M54 to M6 Link Road

**8.8 O(D) Draft Statement of Common
Ground with Staffordshire Wildlife Trust**

**8.8 O(D) Draft Statement of Common Ground with
Staffordshire Wildlife Trust**

Version	Date	Status of Version
2 (P03)	3 November 2020	Issue to the ExA for Deadline 1

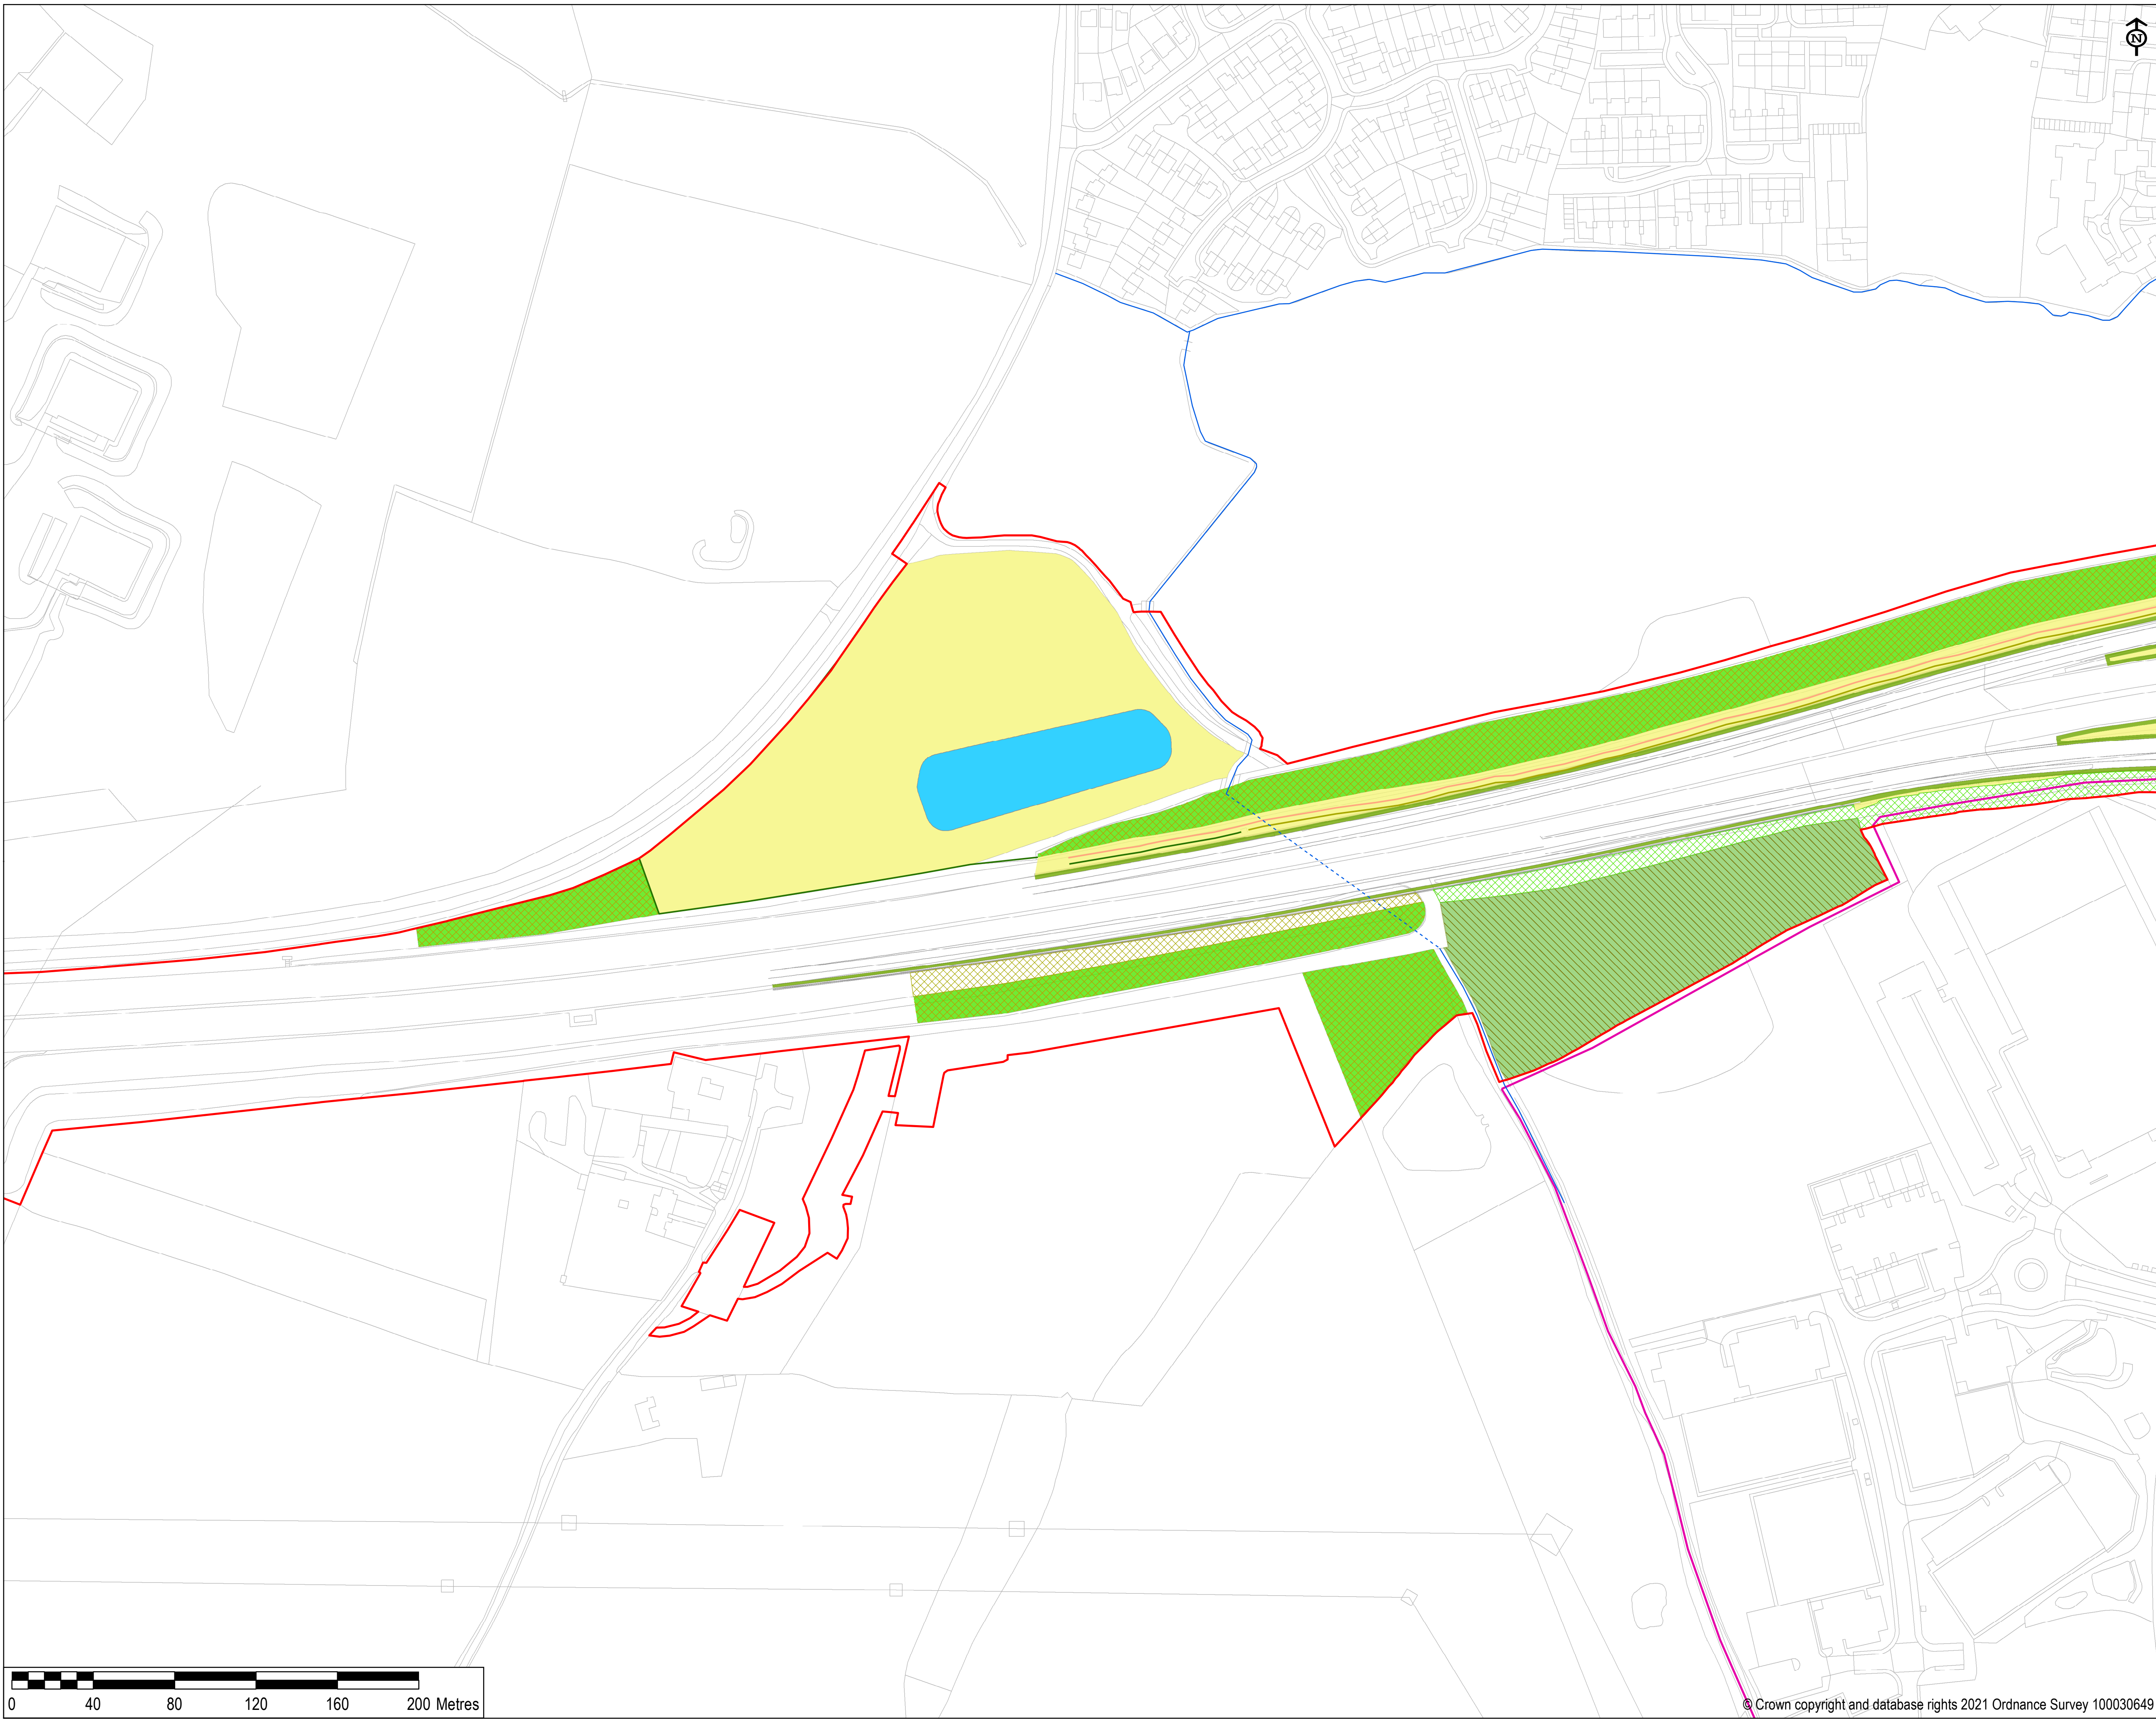
Habitat restoration RR-042d	Section 8.8 'Design, mitigation and enhancement'	The assessment does not appear to include restoration of retained habitats. This could contribute a significant number of units in a shorter time than habitat creation from scratch. Avoiding the	As noted in the Environmental Statement, Chapter 3: Assessment of Alternatives [APP-042/6.1] the Scheme has been carefully designed to minimise the impact on areas of ancient woodland through the optioneering process, the design of the Scheme and consideration of construction methods. Since the Preferred Route Announcement, the ground-level	Under discussion	High

Issue	Sub-section of the ES	Staffordshire Wildlife Trust Comment	Highways England Response	Status	Agreement likely (App)? ¹	Agreement likely (IP)?
		small direct impact on ancient woodland would also mean more habitat creation could be counted.	free-flow arrangement has been adjusted to incorporate engineered retaining structures around M54 Junction 1 to avoid the direct loss of ancient woodland at Whitgreaves Wood (noted as Oxden Leasow Wood on the Ancient Woodland Inventory) (adjacent to the westbound carriageway, west of Junction 1). Measures have been incorporated into the Scheme to ensure that no land within Whitgreaves Wood is required for the construction of the Scheme and no trees within the wood would be directly affected by the construction of the road.			
Habitat restoration RR-042n	Section 8.8 'Design, mitigation and enhancement'	Ancient woodland and Veteran Trees Within Brookfields Farm SBI – 0.0015 ha direct loss; 0.04ha assumed loss due to incursion into the 15 m buffer zone and a further 0.078 ha assumed lost as a result of the change in air quality. Provision of 3.08 ha of broad-leaved plantation (7:1 ratio) has been agreed with Natural England. Direct losses should be avoided by amending the road embankment to a retaining wall adjacent the site.	Described in Paragraph 8.13.22 of the Case for the Scheme [APP-220/7.1 and subsequent revisions] the alignment of the link road between Brookfield Farm and M6 Junction 11 is governed by a number of constraints including Brookfield Farm business, residential property, fishing pools and the ancient woodland (part of Brookfield Farm SBI). In order to reduce land severance, the alignment has been designed to pass immediately to the east of Brookfield Farm on a long curve before heading north-east towards M6 Junction 11. The alignment has been designed to pass approximately halfway between the ancient woodland and the fishing pond at Brookfield Farm, this is in order to achieve a suitable alignment into M6 Junction 11. Due to the embankment height of the alignment in the vicinity of the fishing ponds and ancient woodland this does result in the direct loss of an	Under discussion	High

Issue	Sub-section of the ES	Staffordshire Wildlife Trust Comment	Highways England Response	Status	Agreement likely (App)? ¹	Agreement likely (IP)?
			<p>area of 15m² of the ancient woodland. Proposed changes to the Scheme formally submitted in October 2020 alter the impacts of the Scheme on some existing habitats and now avoid the direct loss of ancient woodland. These changes are reported in Version 3 Chapter 8: Biodiversity [AS-083/6.1].</p> <p>Restoration of ancient woodland is proposed within Oxden Leasow (Whitgreaves wood) and Brookfield Farm SBI and LWS. The OEMP [APP-218/ 6.11 and subsequent revisions] Table 3.4, ref D-BIO11 states that 'In combination with the compensatory planting, conservation led management of both ancient woodlands (Oxden Leasow (Whitgreave's Wood) and the area within Brookfield Farm SBI and LWS) would seek to develop and improve upon the woodland structure, enhancement measures would include selective thinning'. These restoration measures are not captured within the metric as irreplaceable habitats such as ancient woodland are excluded from the calculations of losses and gain of biodiversity units (as recommended within TN3 of the CIRIA best practice guidance).</p> <p>Existing areas of ancient woodland for retention and enhancement, are shown on Figure 2.3 Draft Environmental Masterplan Sheet 1 of 5 [APP-059/ 6.2 and AS-088/6.2] for Brookfield Farm SBI and LWS; and Figure 2.6 Sheet 4 of 5 [APP-062/ 6.2 and AS-088/6.2] and Figure 2.7 Sheet 5 of 5</p>

Issue	Sub-section of the ES	Staffordshire Wildlife Trust Comment	Highways England Response	Status	Agreement likely (App)? ¹	Agreement likely (IP)?
			<p>[APP-063/6.2 and AS-088/6.2] for Oxden Leasow (Whitgreaves Wood).</p> <p>General enhancement measures for woodland are included within the OEMP [APP-218/ 6.11 and subsequent revisions]. Table 3.4 ref D-BIO10 states that 'Timber from felled trees shall be used for the creation of deadwood areas within selected areas of retained habitat for saproxylic (dead wood loving) species, with some placed in the understory of woodland blocks to enhance woodlands. Felled trees would be retained on site as whole boughs and trunks. These sorts of habitat enhancements are not shown within the biodiversity metric calculation as they may not necessarily lead to a favourable change in the condition (in terms of the metric) of the habitat being enhanced.</p> <p>Sections of retained watercourses (exact locations to be determined during the detailed design stage) will be enhanced, which would result in a 2.23% gain in biodiversity units using the river metric.</p> <p>In terms of the restoration of habitats, areas of existing habitats will be enhanced from their original "distinctiveness" and/or "condition" post development. However, as these habitats will be temporarily lost due to construction or the altering of habitat type e.g. changing improved grassland to species-rich grassland, the</p>
